Planning Services Sign Permit Review Form

Date of Submittal	Application Number	Applicant	Landowner
8/26/2025	SIGN2508-0008	Caviness & Cates Building & Development	Moore HL Properties, Inc.

Contact Person	Contact Number
Pamela Geddie	910 778-7902
Sign Location	PIN Number
Darroch Road	0527-40-0333.000

SHEET TITLE:
SIGNAGE DETAILS

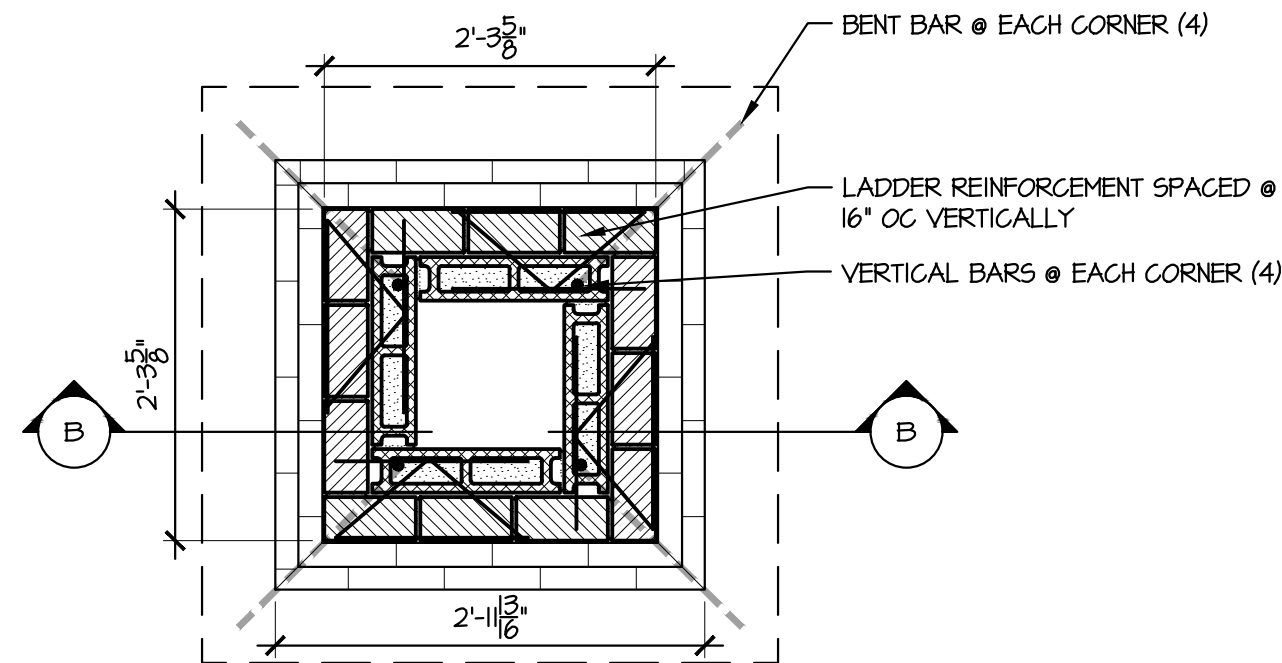
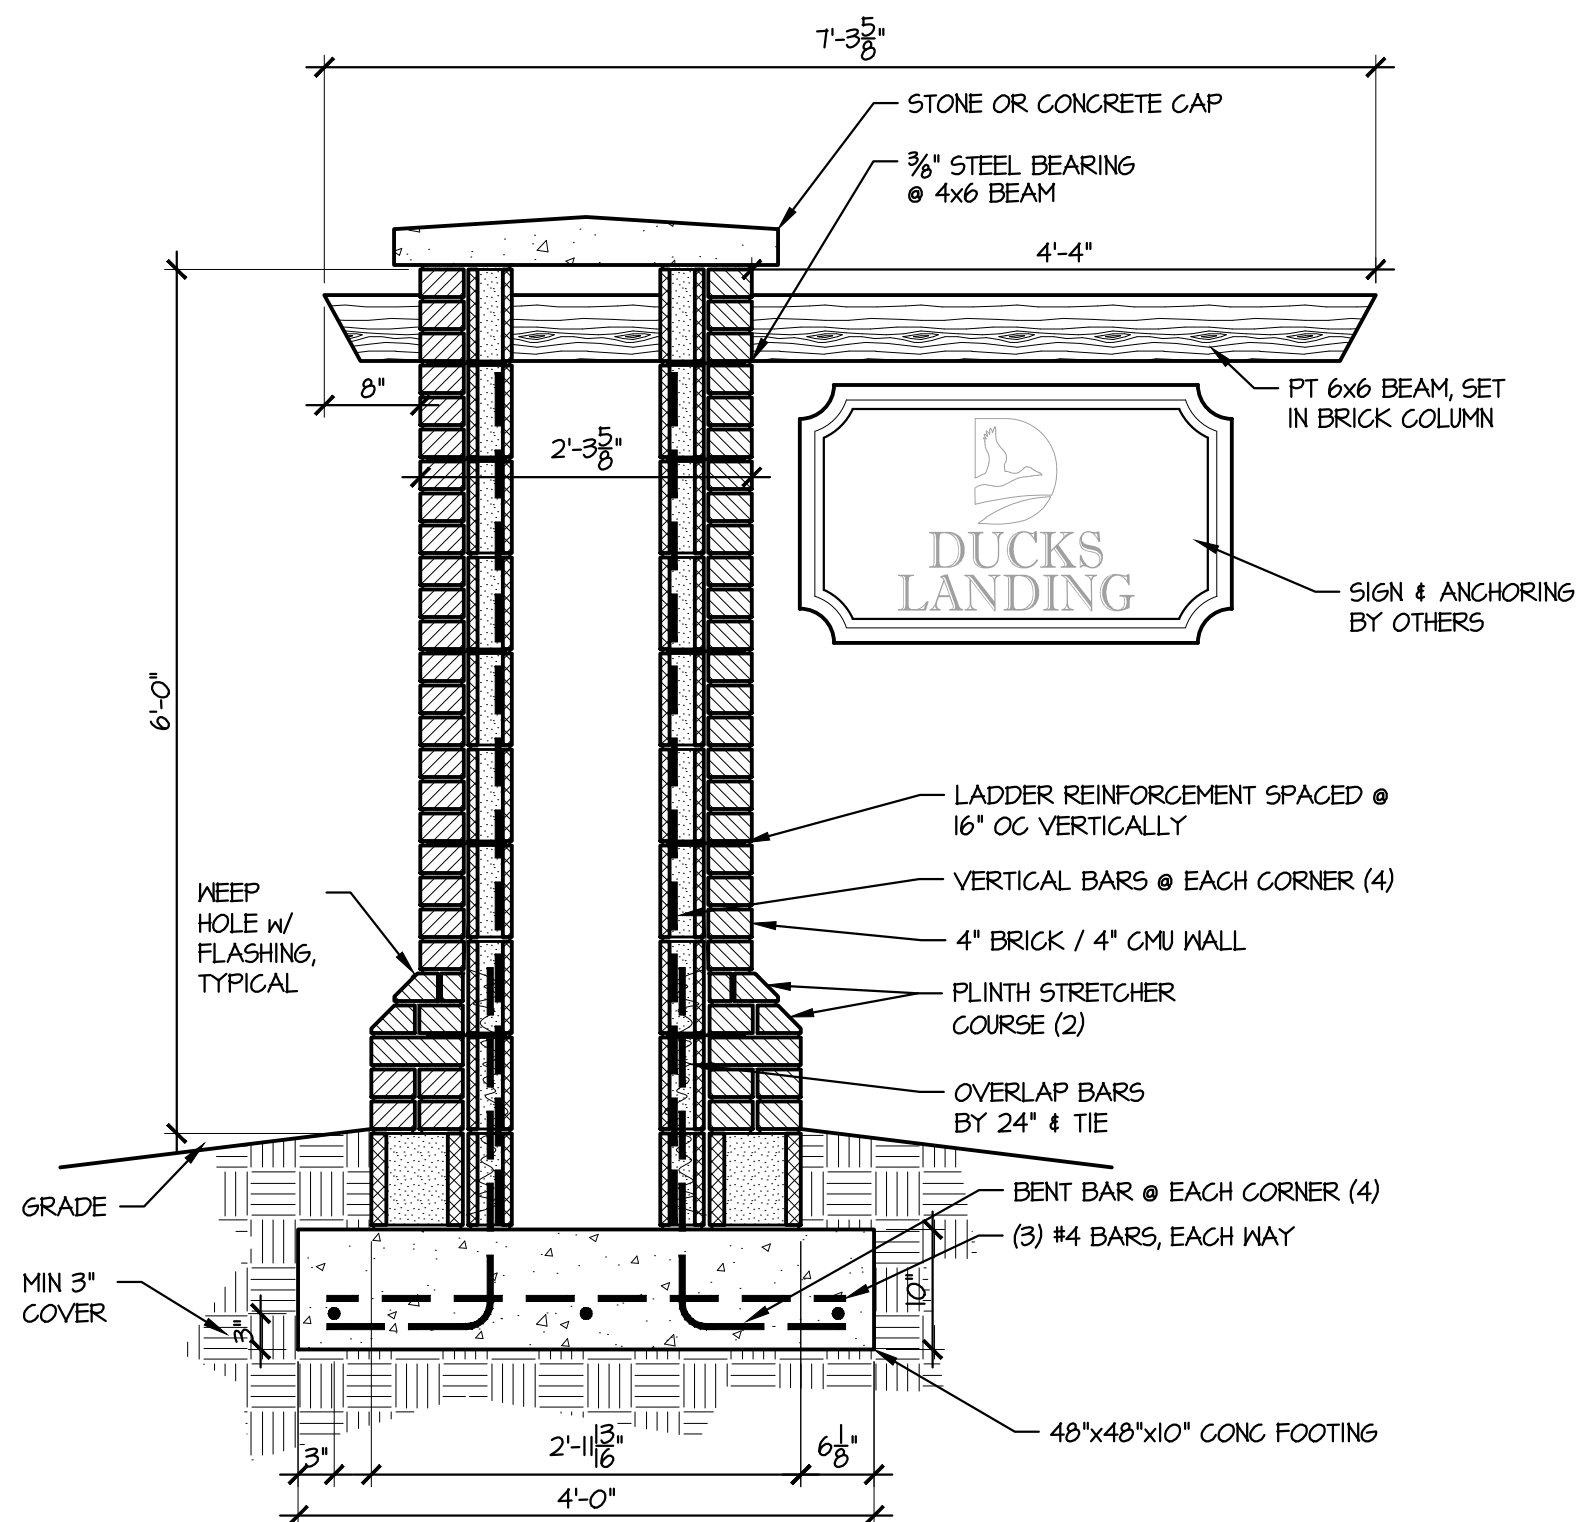
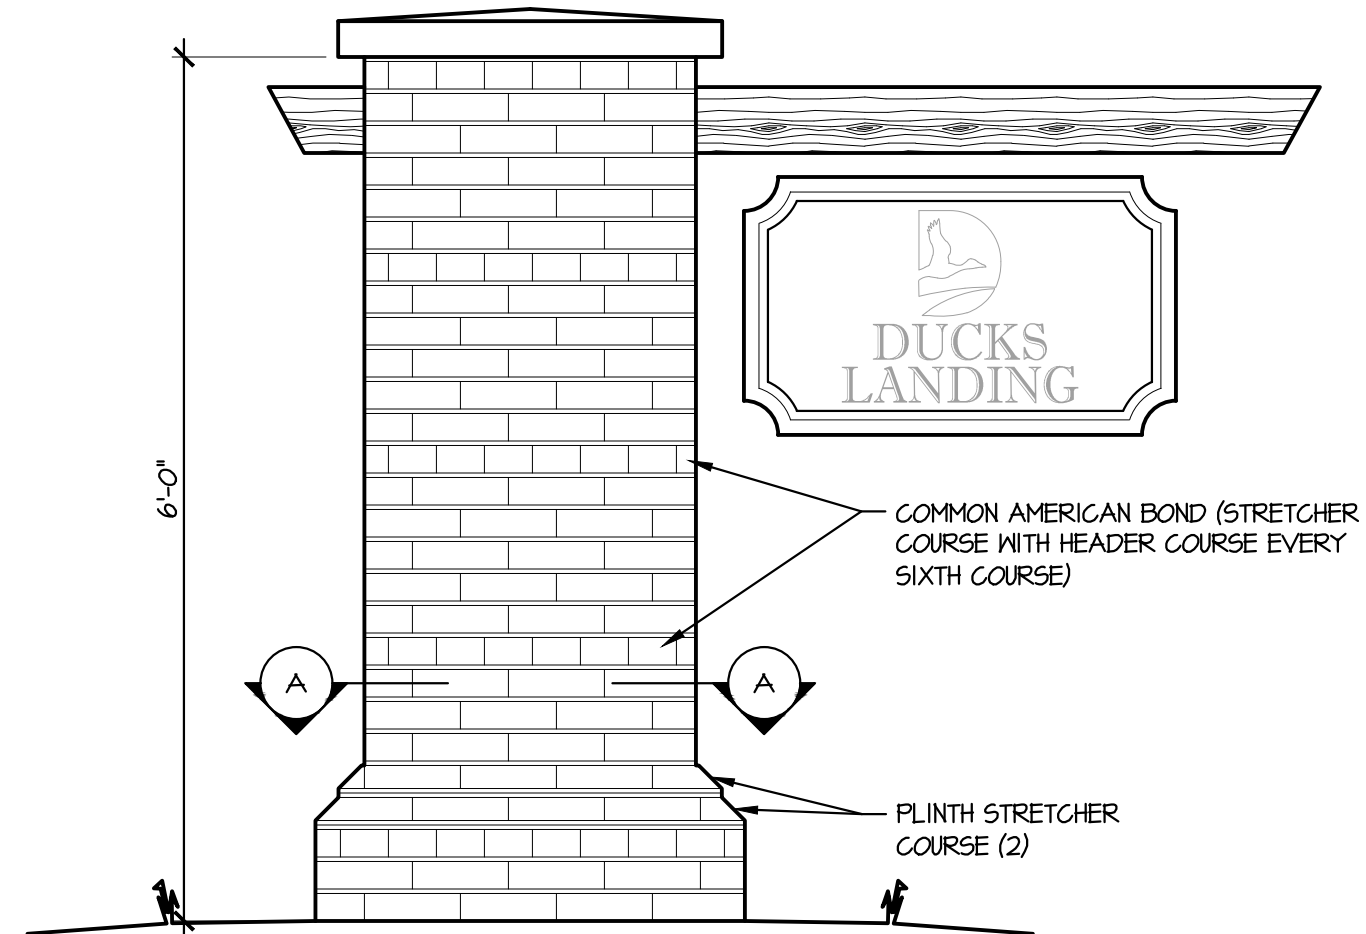
Comments
Signs located at intersections have a minimum setback of 20 feet as measured from each right-of-way line or property line in both directions. Current site plan places the sign at 9.7' measured from Darroch Road.
